Department of Planning and Environment
4 Parramatta Square, 12 Darcy Street
Parramatta NSW 2124

Your Ref	SSD-71558711
Our Ref	NCA/6/2024
Contact	Douglas Bennett
Telephone	02 9806 5405
Email	dbennett@cityofparramatta.nsw.gov.au

COUNCIL SUBMISSION TO REQUEST FOR ADVICE ON EIS – MIXED-USE PRECINCT WITH IN-FILL AFFORDABLE HOUSING – HUGHES AVENUE, MELROSE PARK SOUTH-WEST

OS4-L-403

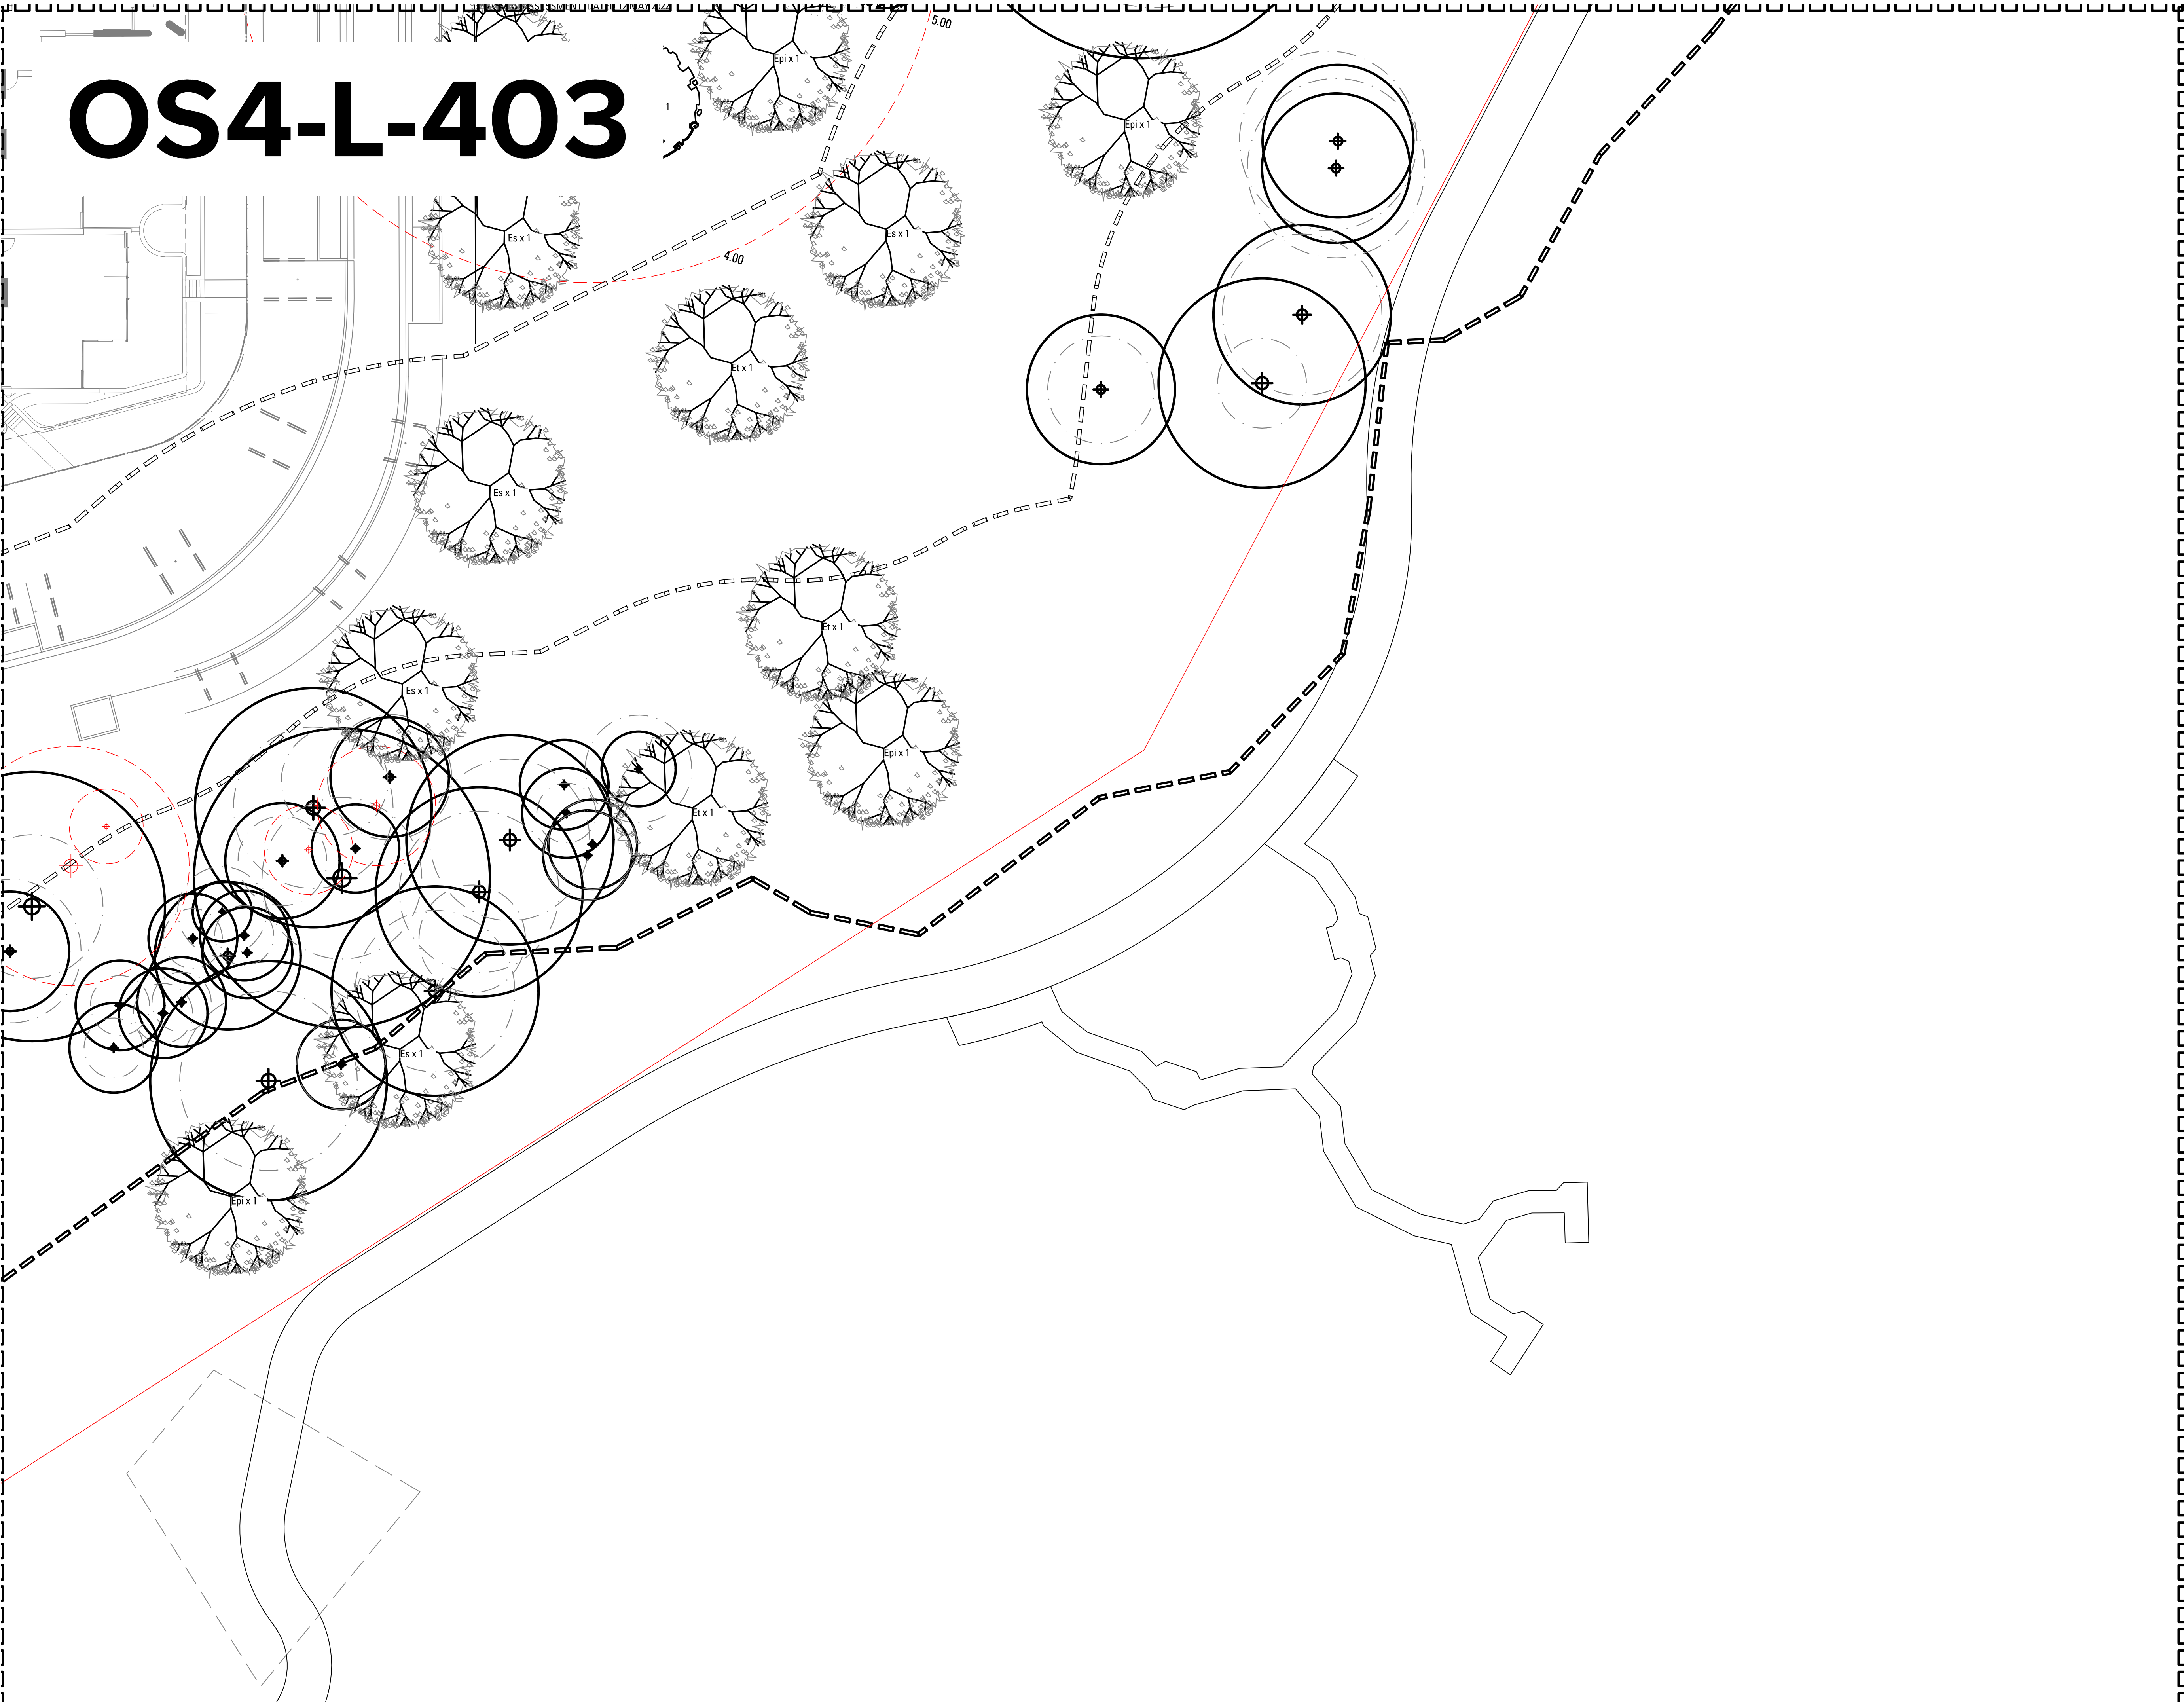
Council requests that *Pennisetum sp.* be replaced with *Poa labillardieri* and/or *Poa poiformis* as *Pennisetum* is an undesirable species in this location.

Maximum grades of 1:5 (Turf) and 1:3 (Garden beds) should be provided (and confirmed by showing levels on plans) to facilitate safe maintenance access. In addition, turf zones require minimum 2m clearances to pathway edges for mower access.

Riparian planting palette should comprise species from endemic ecological communities (Sydney Coastal Sandstone Foreshores Forest / Sydney Enriched Sandstone Moist Forest / River Mangrove Forest / Coastal Saltmarsh) to enhance ecological integrity.
